From: Zac Denton
Sent: 13 December 2018 08:27
To: Amanda Scholes
Subject: FW: !3 Norfolk Road, Littlehampton. LU/247/18/HH.

This is an objection to LU/247/18/HH.

PROPOSED GROUND FLOOR PLAN Scale 1:50

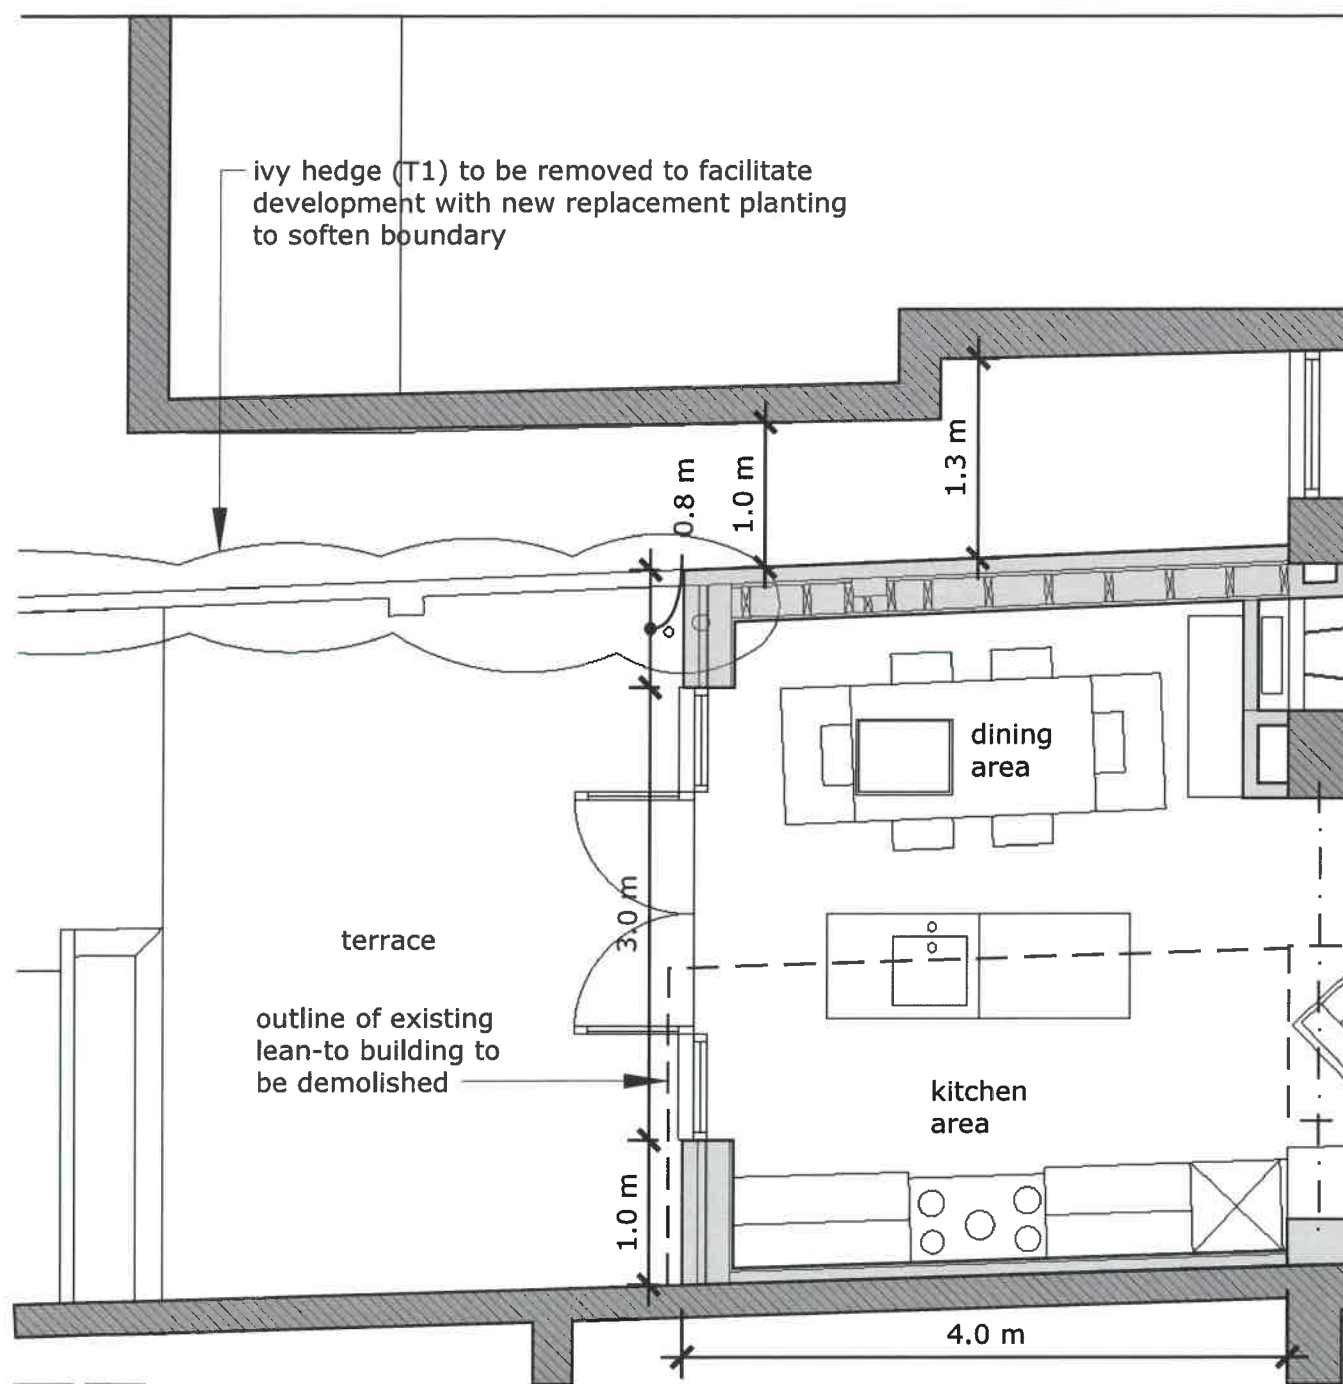
In addition to the previous comments it appears that no adjustment has been made to the length of the proposed extension and adding that to the height and proximity to our building only adds to the claustrophobic effect this will have on our daily lives.

SOUTH ELEVATION Drg no 2018/MEL/04A Aug 2018 Scale 1:50@A3

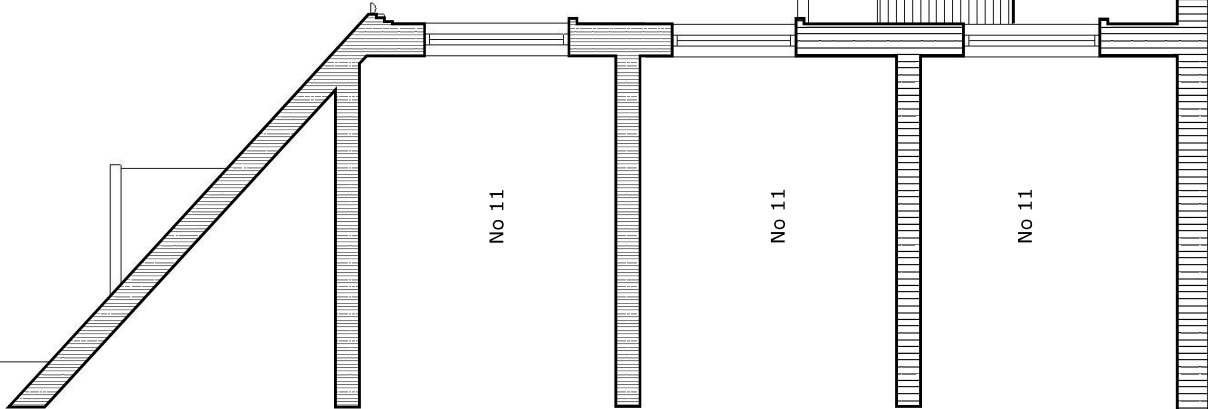
Further to our conversation in regards to the above, we are very disappointed to see that the very small changes made to the proposed extension, will make little or no difference to the light loss and view of a wall instead of sky from our living room area and kitchen area.

From the plans one can see the wall of the extension totally over shadows our rear window and kitchen area and will still be almost 1 metre higher than the existing party wall and fence.

Please note the fence belongs to No11 and we would not be happy for the fence to be removed without discussion and agreement as we have plants attached in places to the fence.
